OXFORDSHIRE COUNTY COUNCIL'S RESPONSE TO CONSULTATION ON THE FOLLOWING DEVELOPMENT PROPOSAL

Application no: 15/00760/F-2

Proposal: Development of a new Local Centre comprising a Convenience Store (use class A1), Retail Units (flexible use class A1/A3/A5), Pub (use class A4), Community Hall (use class D1), Nursery (use class D1), Commercial Units (flexible use class A2/B1/D1) with associated Access, Servicing, Landscaping and Parking with a total GEA of 3,617 sqm

Location: North And South Arcade At Bicester Eco Town Exemplar Site Charlotte Avenue Bicester

COMMERCIAL STREET DRAINAGE STRATEGY

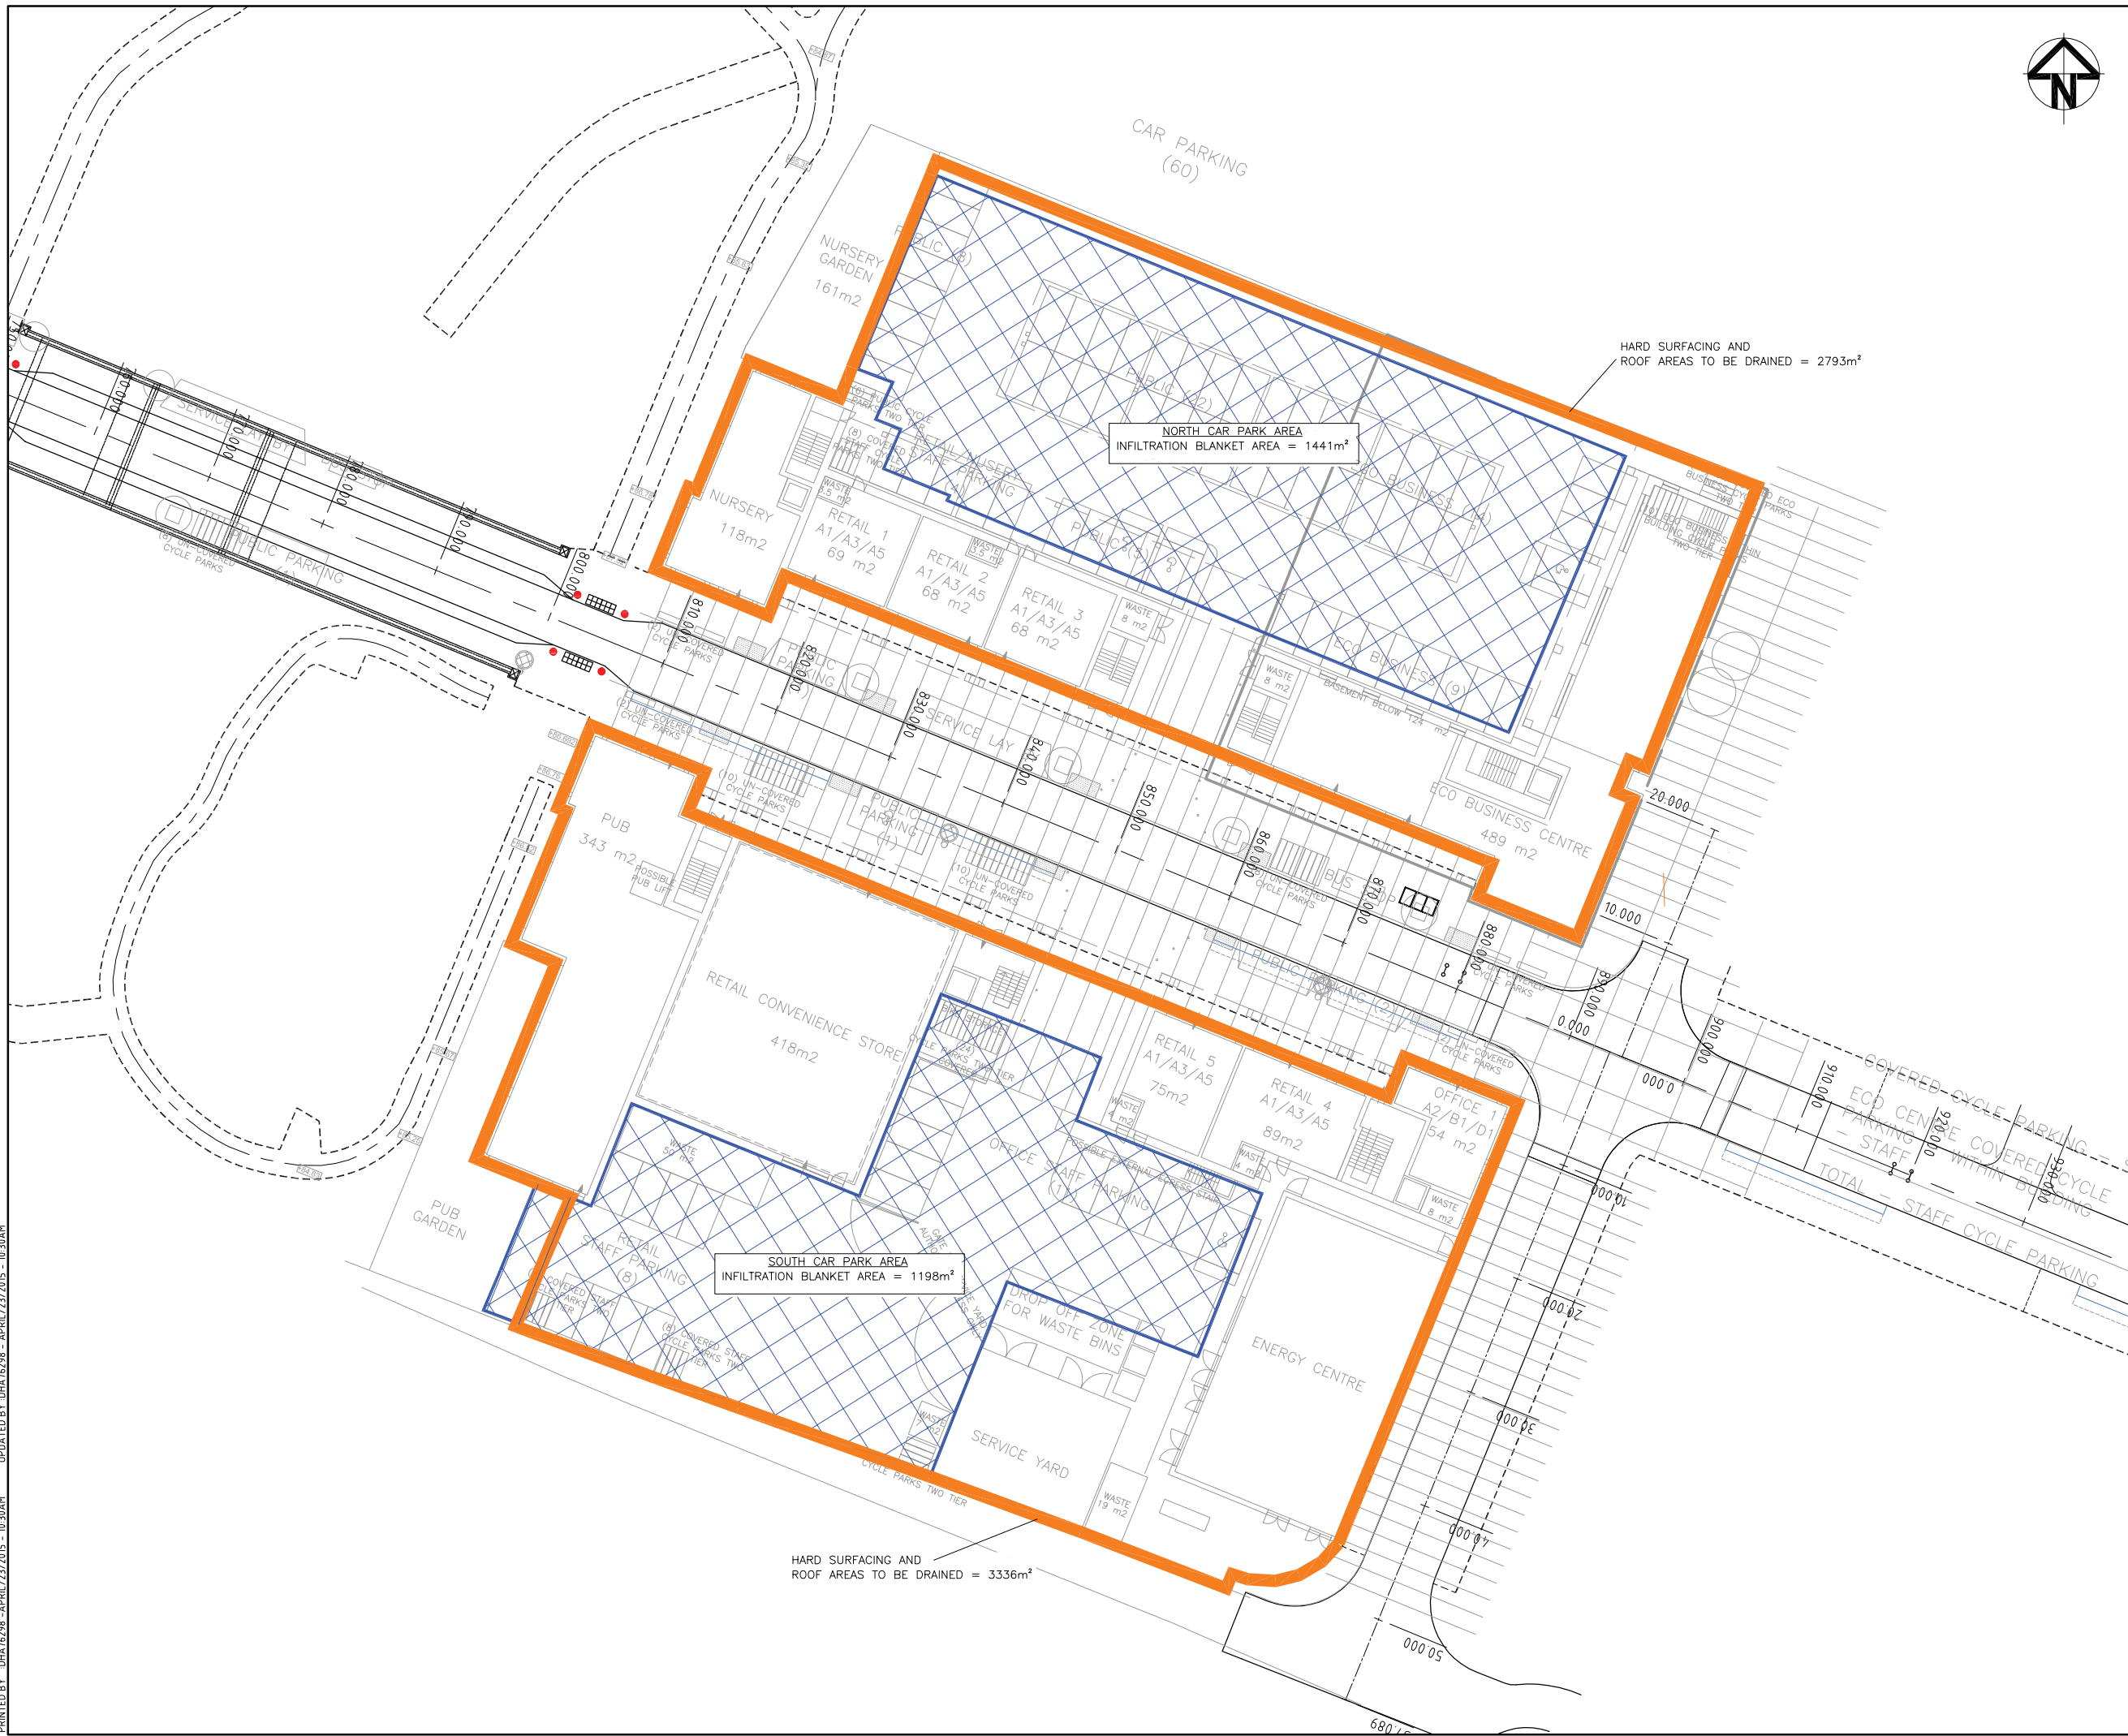
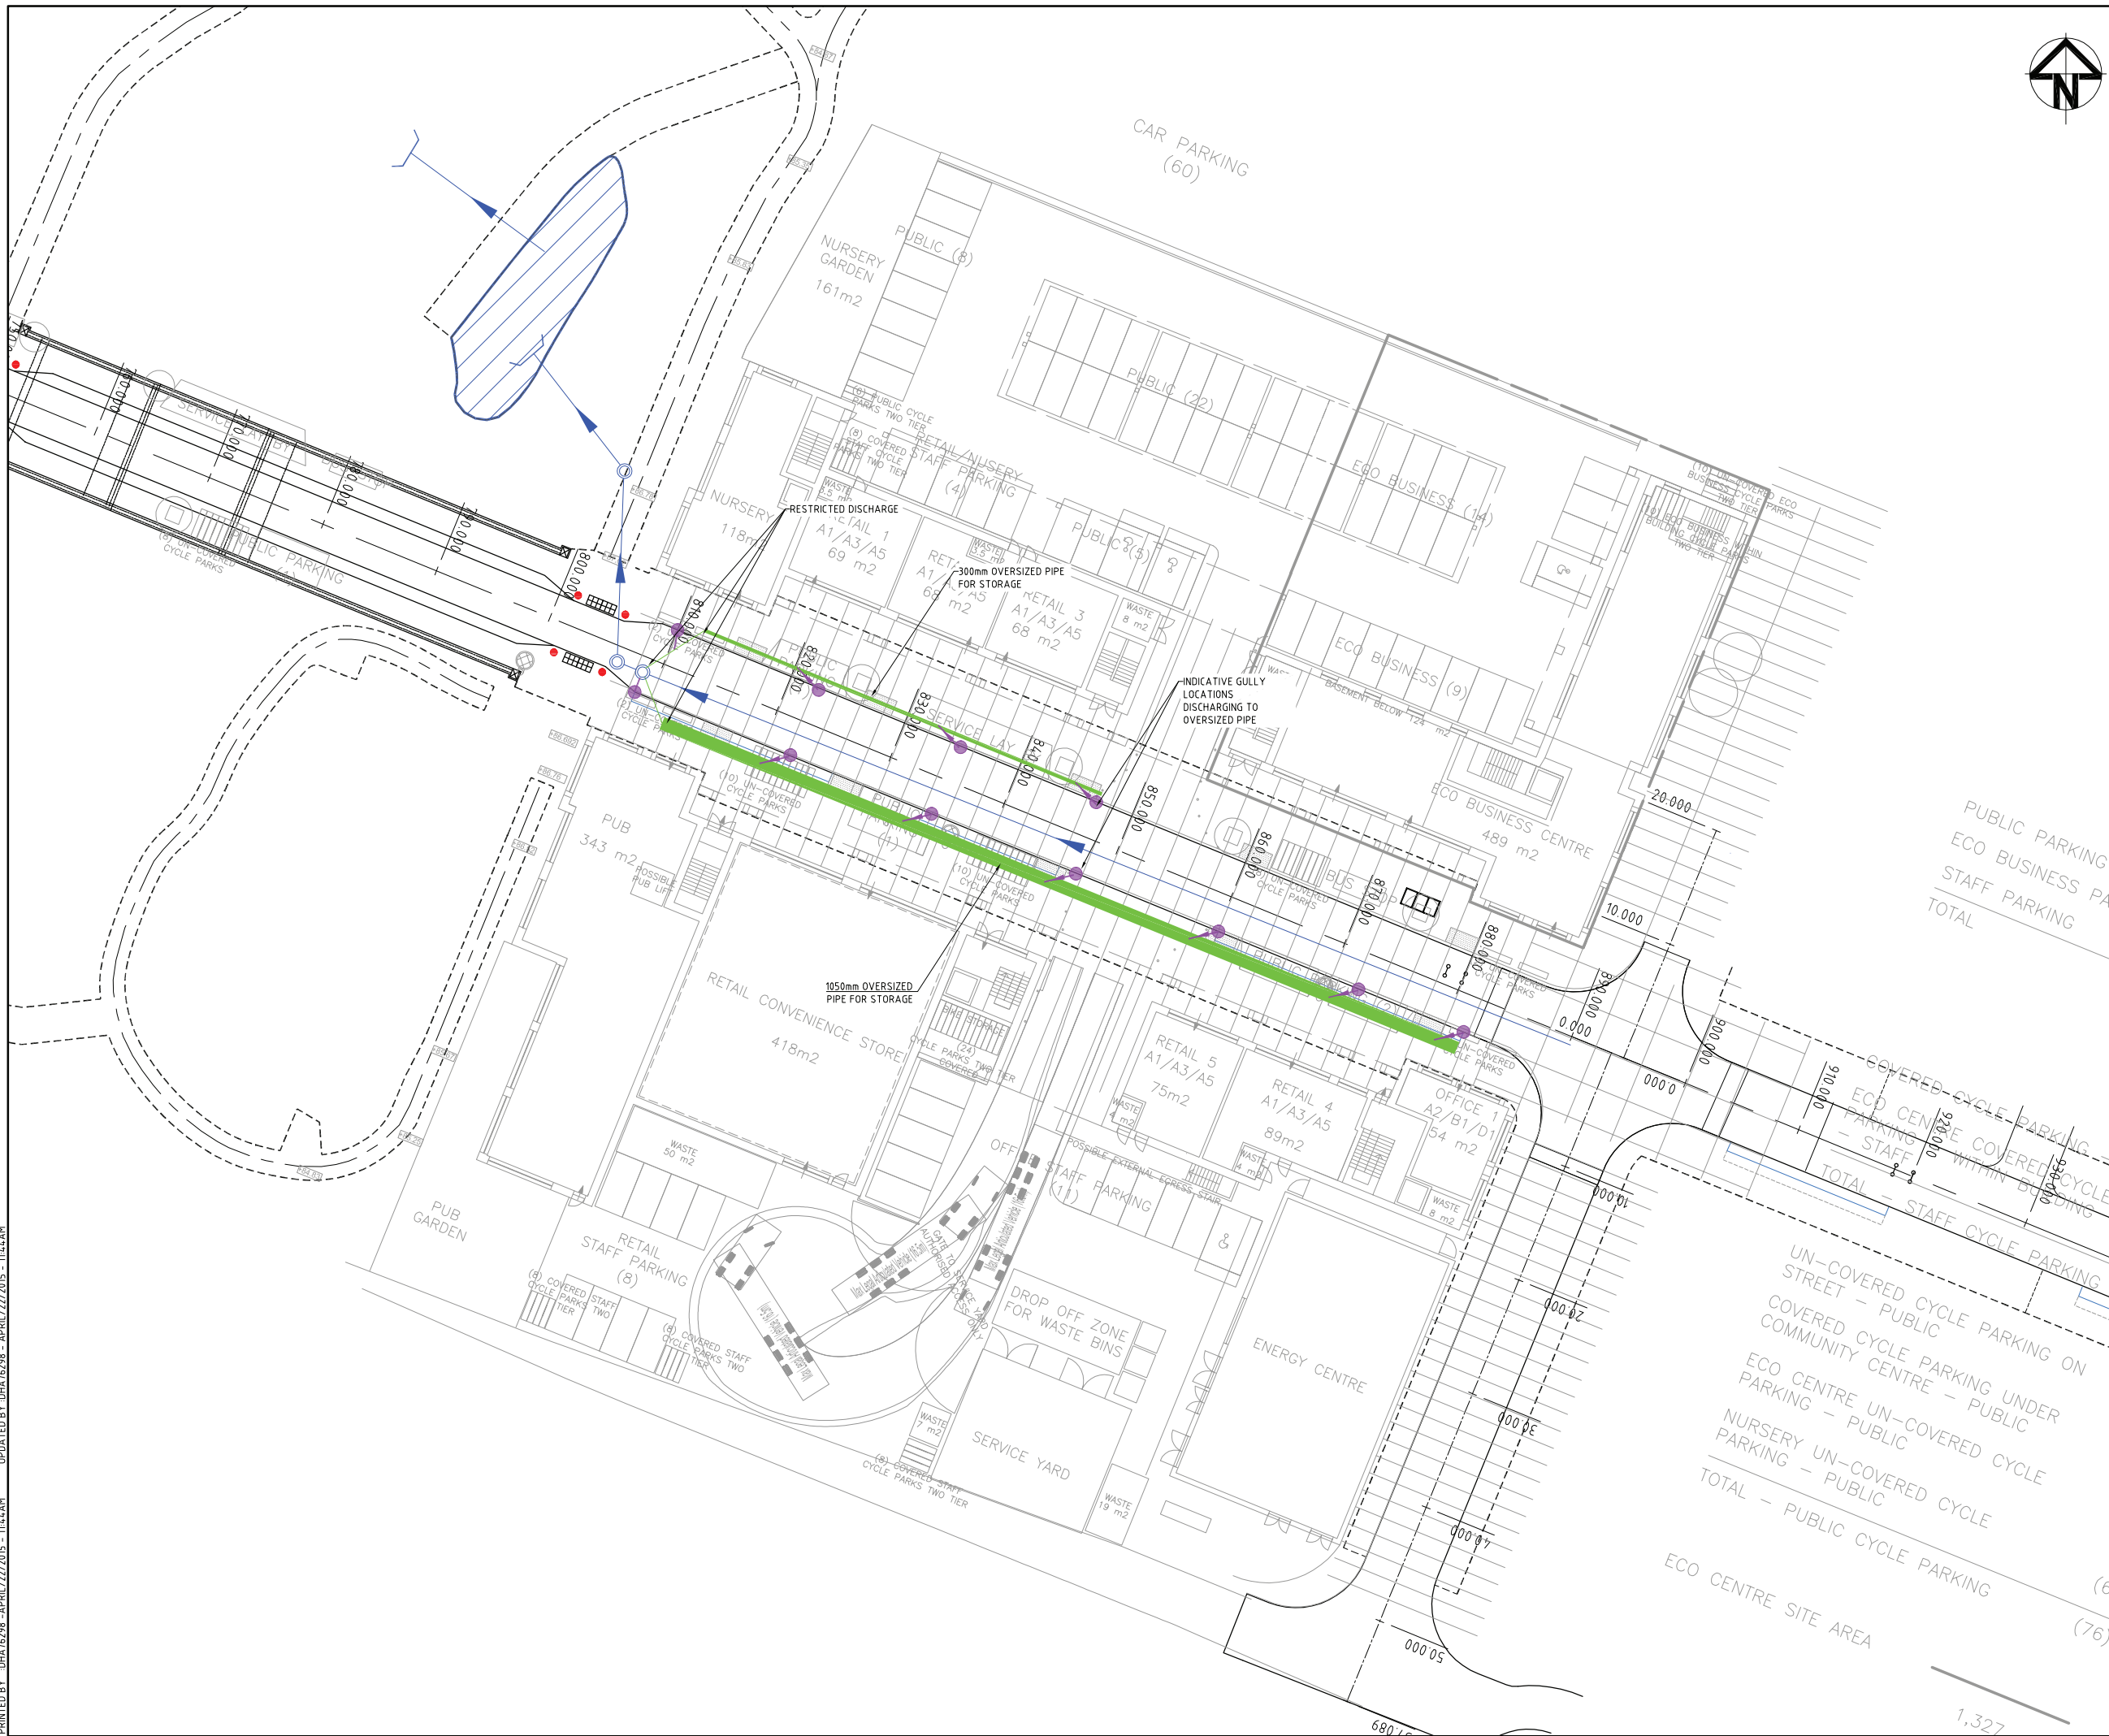
What have also been omitted from the layout scheme are the open drainage channels in the local centre area to the south of the spine road at the road edges.
